August 15, 2023

SUBJECT: WDFW COMMENTS ON LP-23-00003 McAllister Summit

Thank you for the opportunity to comment on the LP-23-00003 McAllister Summit application concerning the dividing of 2 parcels totaling 11.27 acres into 8 residential lots ranging in size from 0.31 to 8.8 acres. Washington Department of Fish and Wildlife (WDFW) has reviewed the application and supporting documents, including the critical areas report. Our comments are regarding the project's impact on priority fish and wildlife habitats, particularly wetlands and riparian habitats. Specifically, to ensure that if the application is approved that the lots are buildable without incursions into Fish and Wildlife Habitat Conservation Areas (FWHCA).

TYPE "F" STREAM OHWM PER CRITICAL AREA REPORT BY SEWELL WETLAND CONSULTING, INC. DATED 6/20/2022

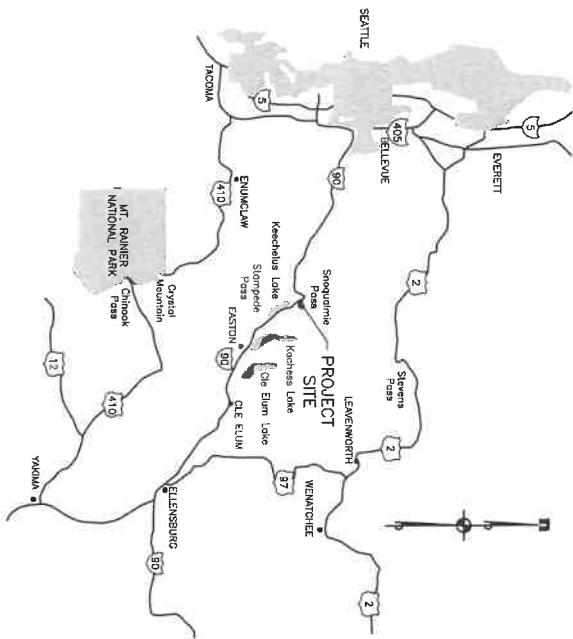
While we appreciate that the critical areas report has outlined Coal Creek correctly as a fish-bearing stream and applied appropriate setbacks, the description of the other mapped Type F stream, in the NW corner, as seasonally dry does not necessarily preclude it being habitat to fish. The stream is shown on the map as being connected to the same stream where nearby WDFW did assess the stream to be fish bearing earlier in 2023. Before the plat is approved, WDFW requests the ability to review the stream with the applicant or their consultant and review and discuss the stream typing of this stream.
